# Rezoning Transportation Analysis

Petition Number: #2022-006

Date	Description
06-23-22	First Review (PDM)
07-20-22	Second Review (PDM)
09-28-22	Third Review (PDM)

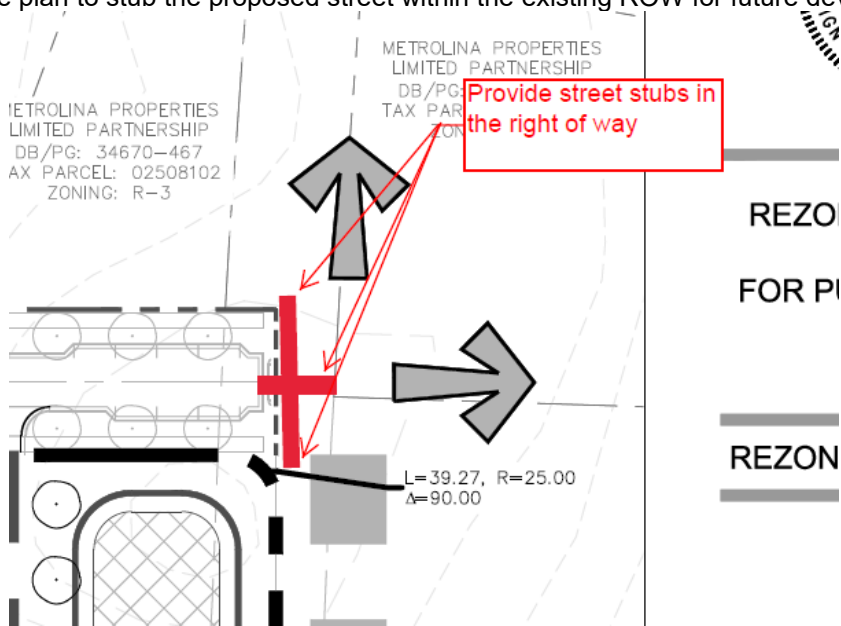
~~A Technical Traffic Memorandum (TTM) is required to be completed by the petitioner and approved by CDOT prior to the permitting approval of the proposed full access street on Northlake Centre Parkway. A conceptual drawing will also be required to be completed by the petitioner showing the feasibility of necessary turn lane improvements for full access. The petitioner will be required to permit and install all roadway improvements recommended in the CDOT approved TTM prior to the issuance of the site's first building certificate of occupancy. The access location on Northlake Centre Parkway will be restricted to right in / right out if the required roadway improvements cannot be installed. Revise site plan and conditional notes to commit to completing the TTM and all recommended improvements as outlined above.~~

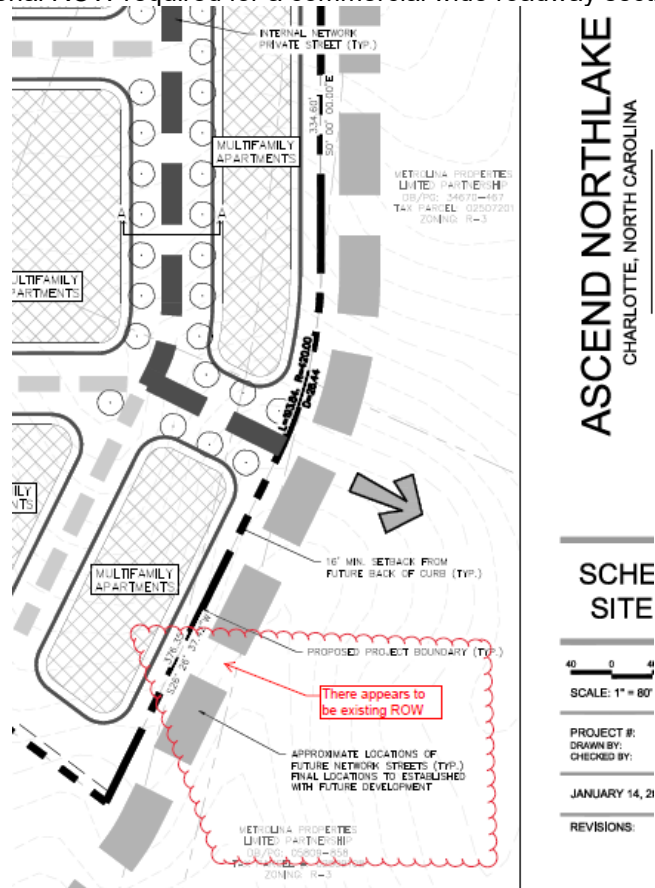
- ~~4. Outstanding Comment from 06-23-22:~~ Revise site plan and conditional note(s) to commit to dedicate 38.5 right-of-way from the road centerline of each public street. The site plan shall label and dimension the right-of-way from the road centerline.
- ~~5. Comment Rescinded 09-28-22:~~ Revise site plan to stub the proposed street within the existing ROW for future development.

7. ~~Comment Rescinded 09-28-22:~~ Revise site plan and conditional notes to reconcile the existing versus proposed ROW along the east side of the property. The future street alignment should fall within existing ROW. Verify ROW width and provide any additional ROW required for a commercial wide roadway section per CLDSM U-05A.

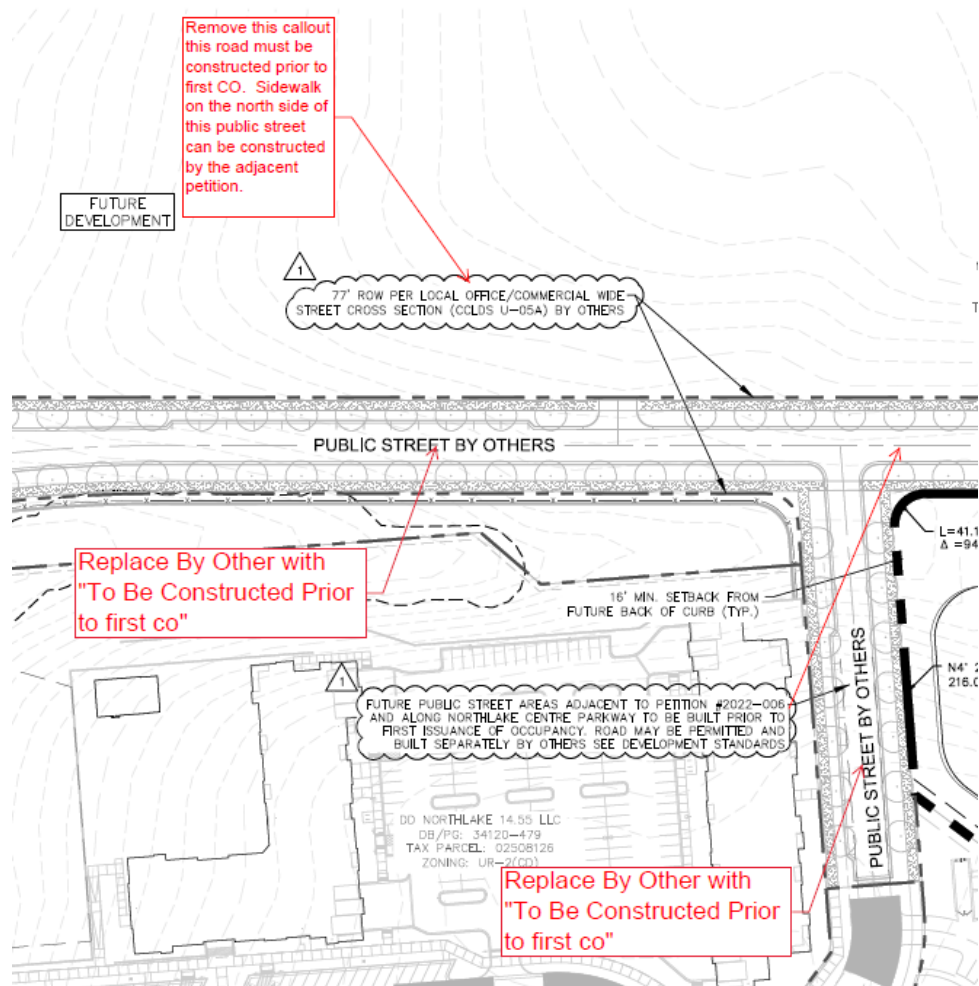
3. ~~**Outstanding Comment from 06-23-22:** Revise site plan and conditional note(s) to commit to installing both public streets that are identified as "public street by others" on the site plan. A new access location on Northlake Centre Parkway will be required by CDOT for this petition. Coordinate roadway responsibilities with RZP 2022-010 as necessary.~~

~~**Clarifying Comment (07-20-22):** Remove "By Others" from the proposed public roadways and adjust callout for street installation commitments to include both public roads.~~
